Ref: 6/2022/1657/HOUSE
Date: 22/09/2022

HISTORIC BUILDINGS AND CONSERVATION ADVICE

RE: 159 Parkway, Welwyn Garden City, AL8 6JA

The application has been amended and is now for the installation of three rear rooflights to facilitate the conversion of the loft to habitable space.

7 Proposed Rear Elevation
1 : 100

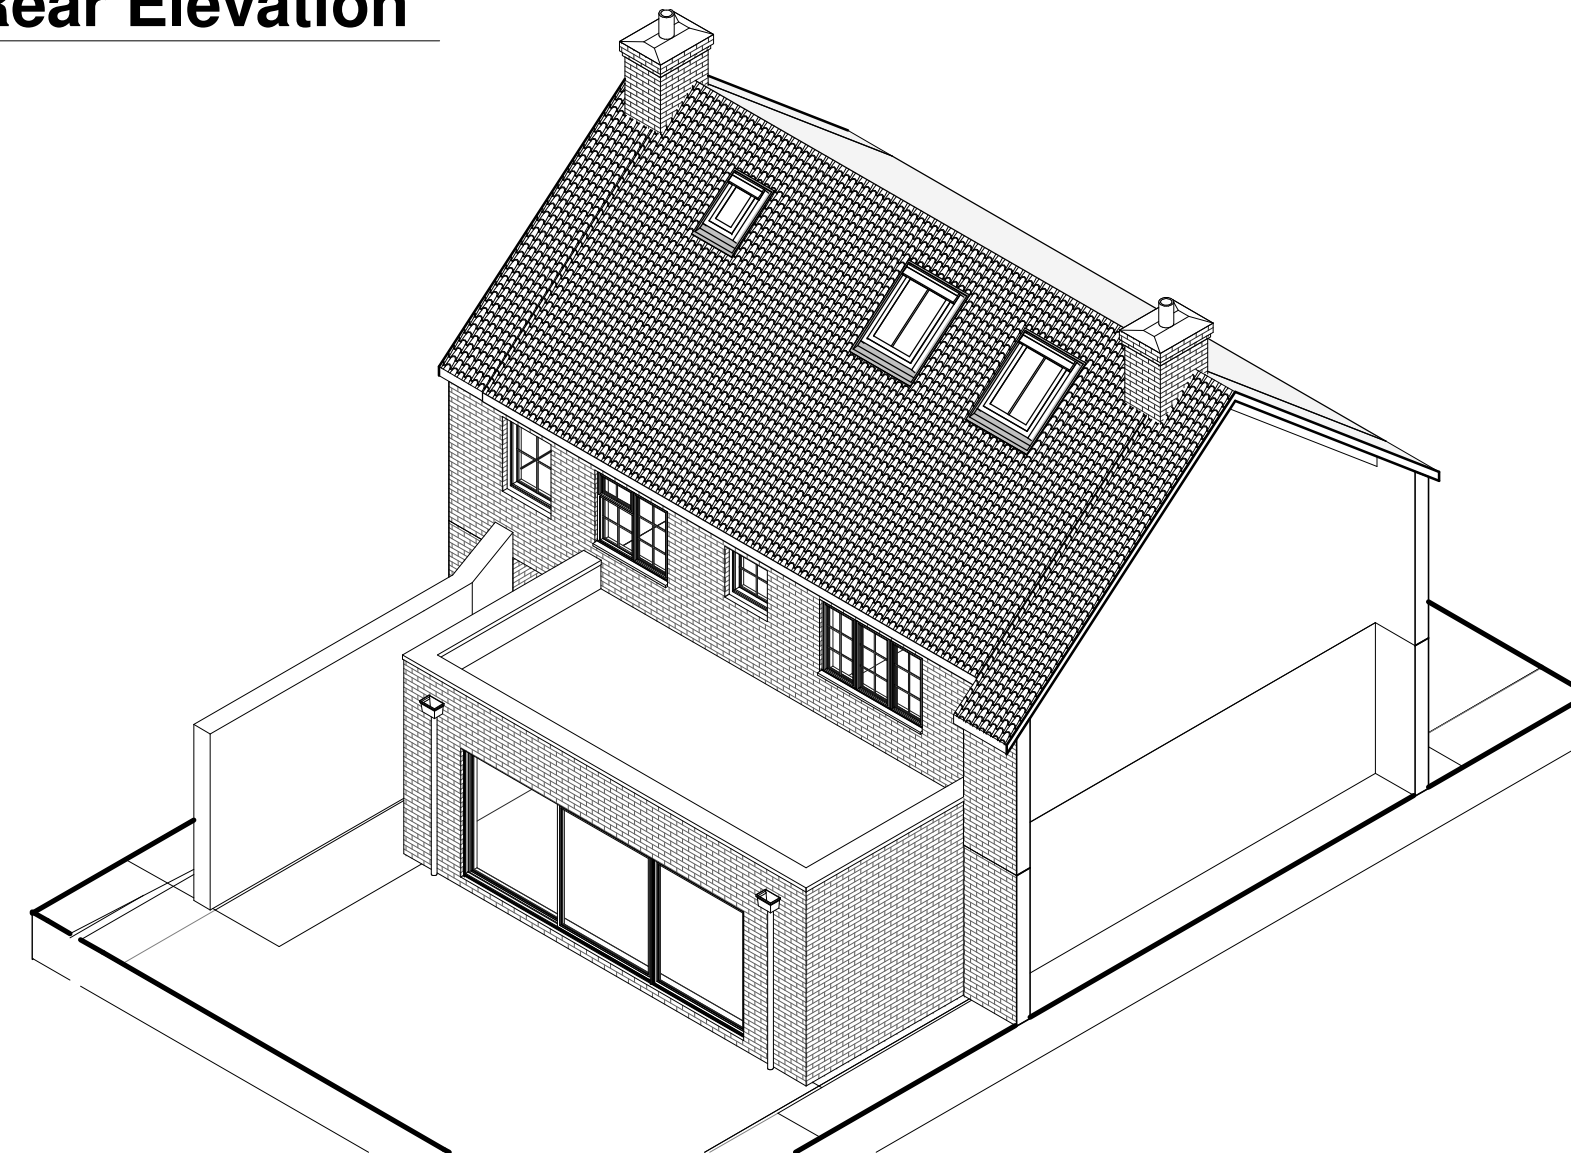
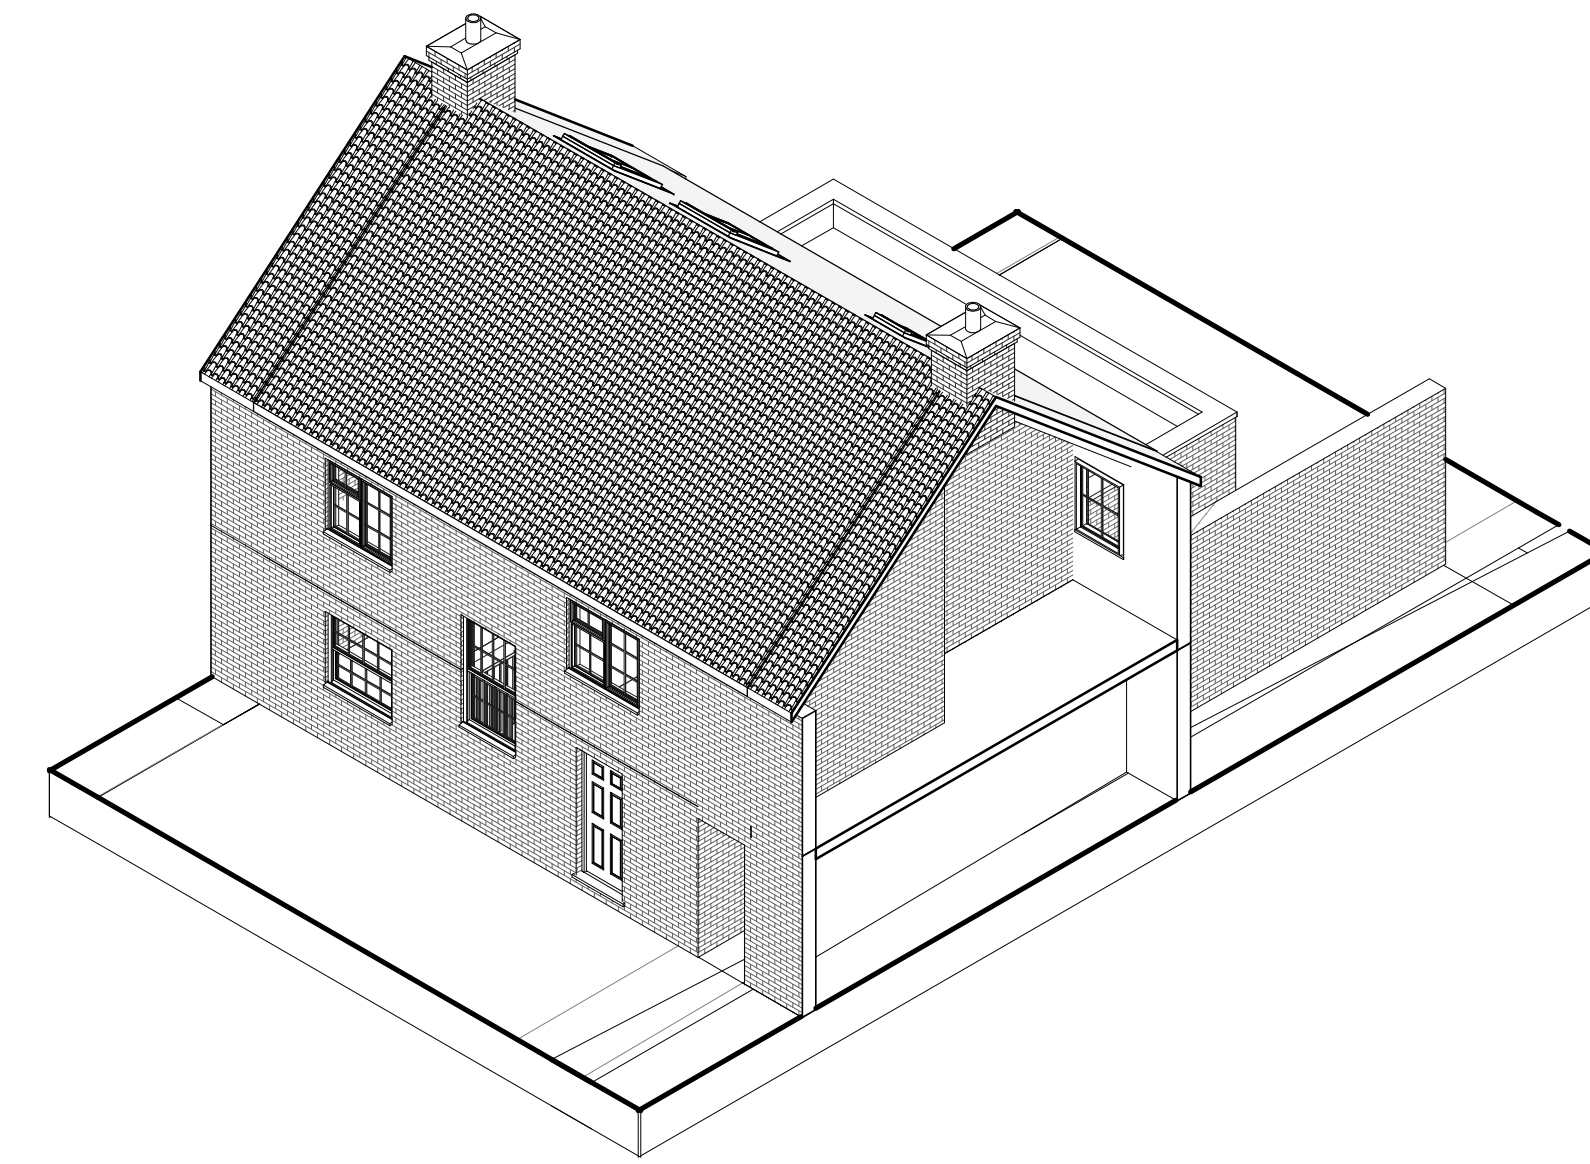
The amendments to remove the rear dormers and front rooflights and install three rear rooflights have addressed previous concerns. The scheme now raises no objection as the character and appearance of the Conservation Area will be preserved and its significance is not harmed, in accordance with Section 72 of the Planning (Listed Buildings and Conservation Areas) Act 1990 and Section 16 of the NPPF.

If the application is approved, it is recommended that a condition requires the submission and approval of details for the rooflights.
